Re: Carlisle and Menaul - Sketch Plat Submittal

12. [PR-2024-009947](#)

[PS-2024-00123](#) – SKETCH PLAT

DRB Project Number: 2024-009947
3535 Menaul-American Square

CARLISLE AND MENAUL COMMERCIAL DEVELOPMENT
BACKBONE INFRASTRUCTURE
PROPOSED DMP

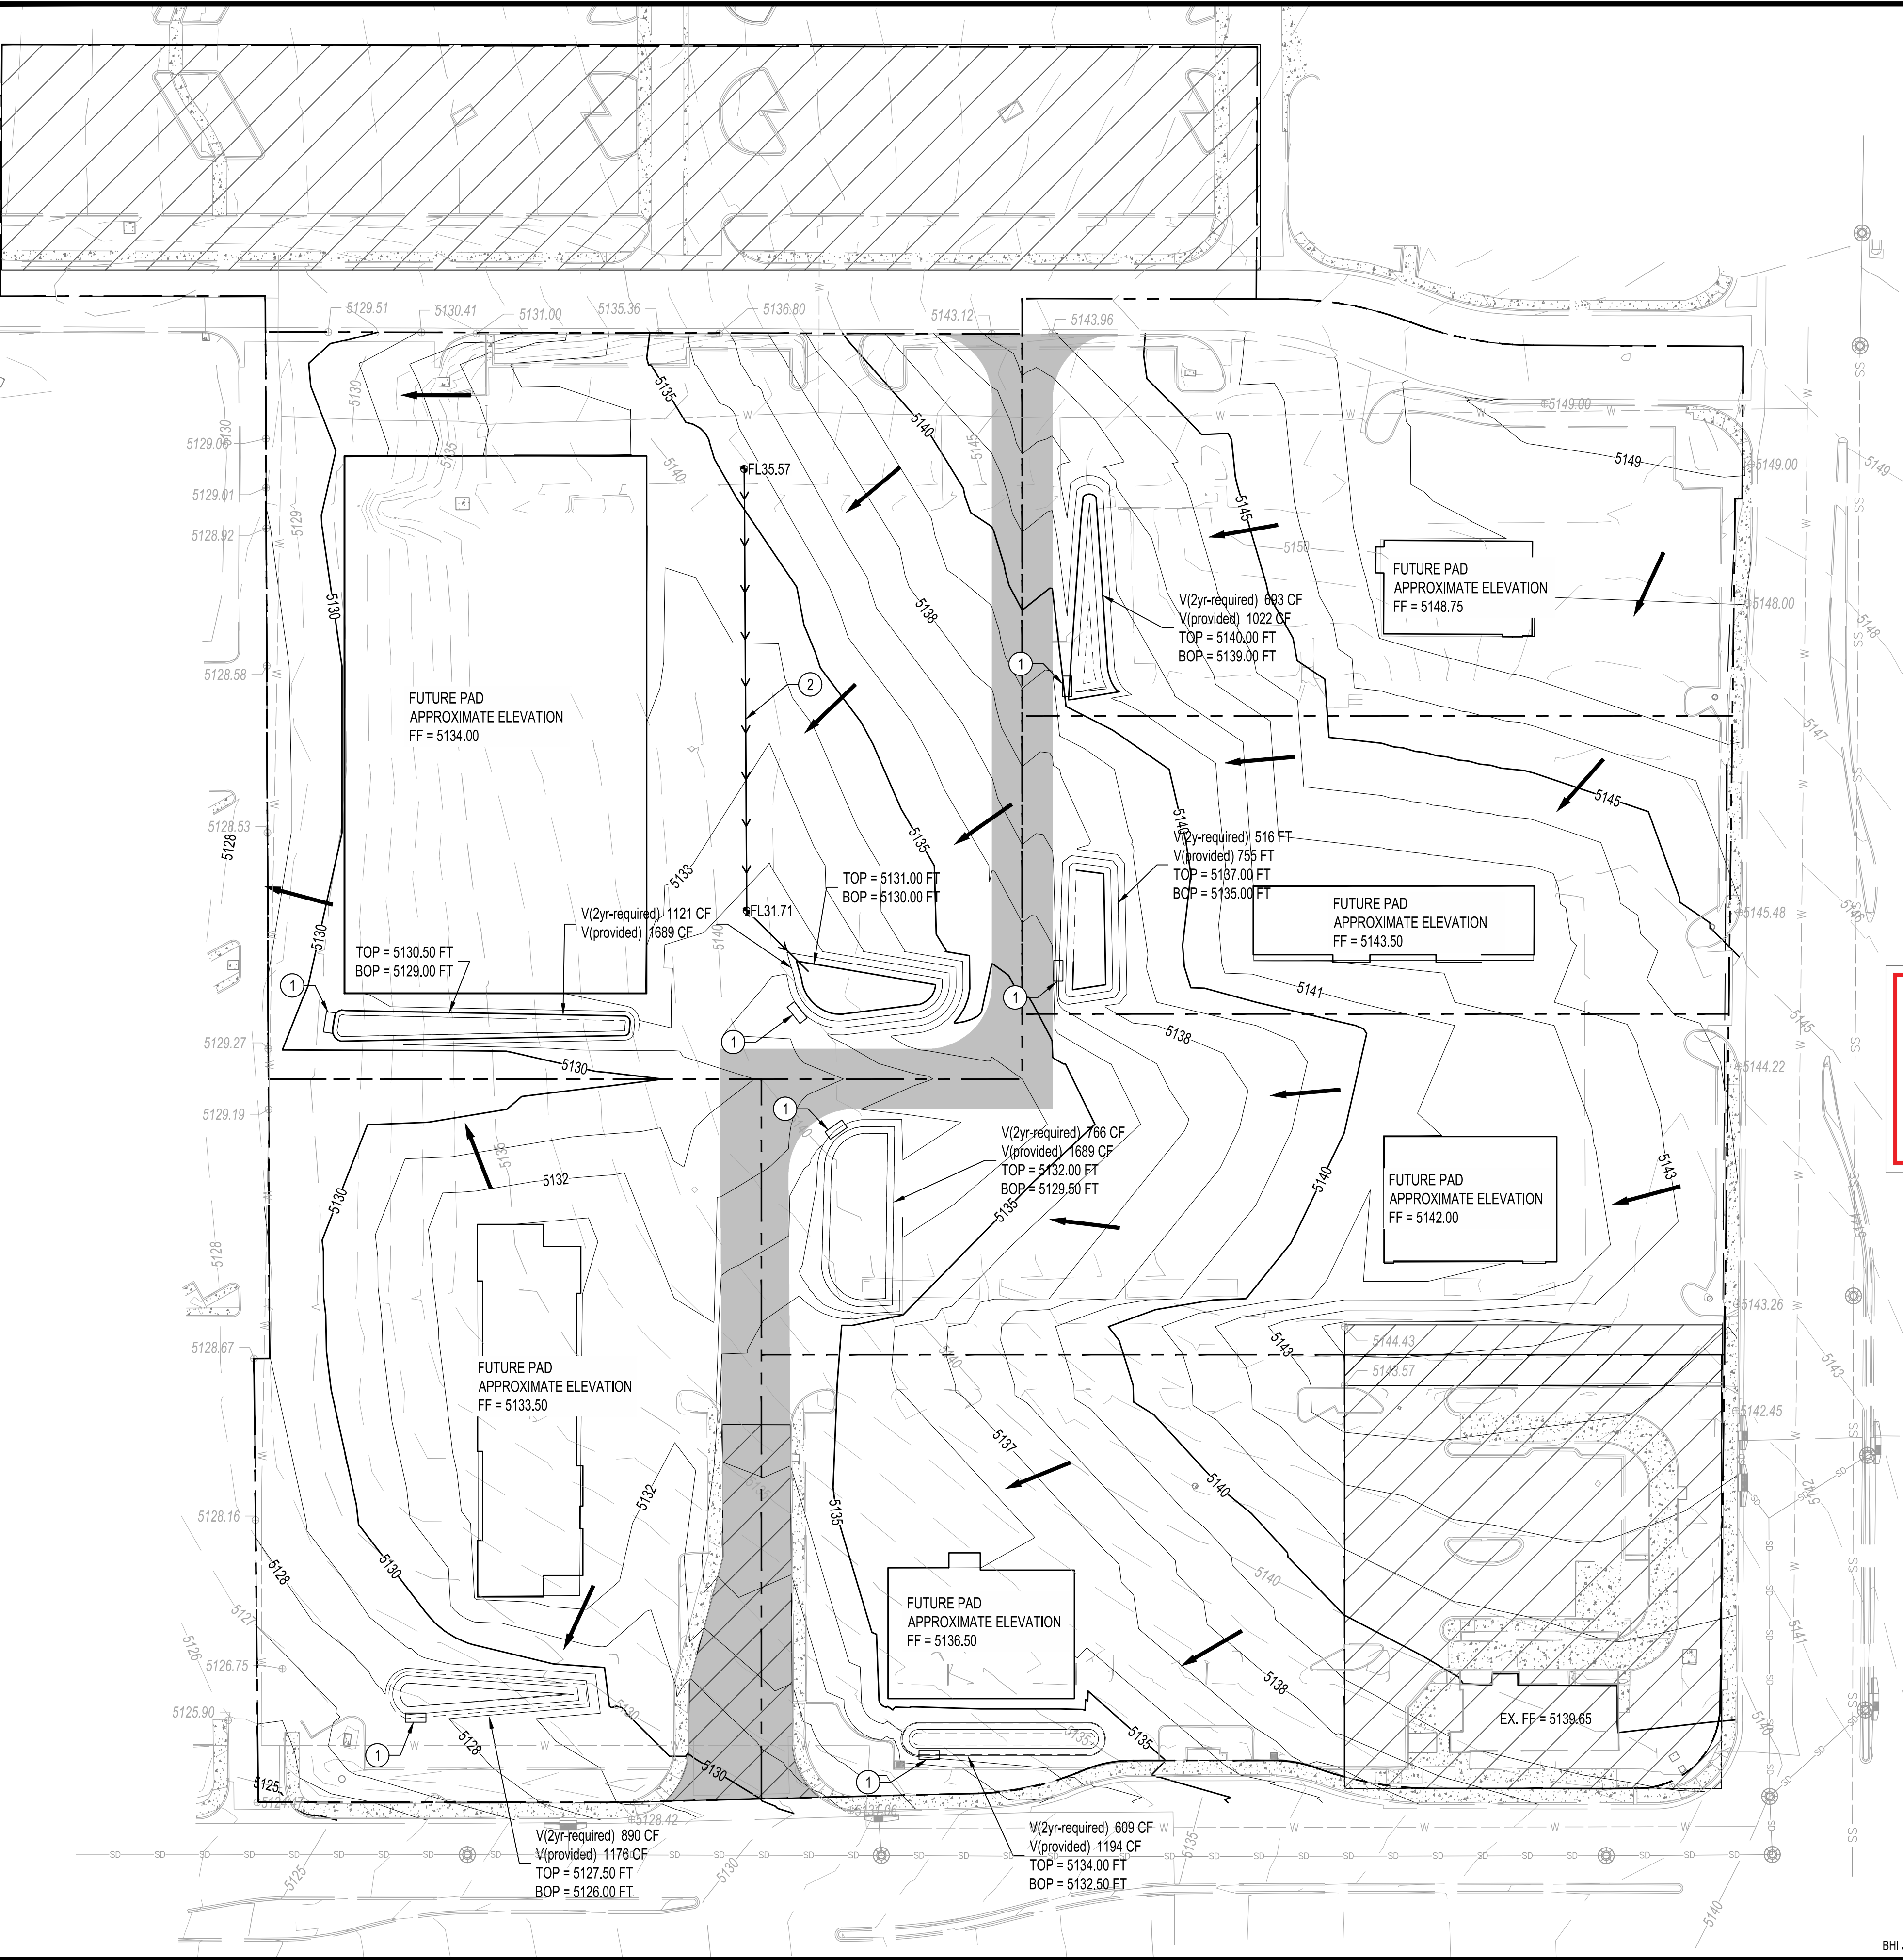
- Hydrology will need to approve a Conceptual Grading & Drainage Plan prior to plat approval.
- Depending on the Conceptual G&D, Cross Lot Drainage Easement note specifying the beneficiary and maintenance agreement may be needed.
- Comment – Prior to submitting for Building Permit, a licensed New Mexico civil engineer will need to submit a Grading & Drainage Plan to Hydrology for review & approval if one of these conditions is met. (500 cy of grading, 1,000 sf of proposed building, or 10,000 sf of proposed paving).
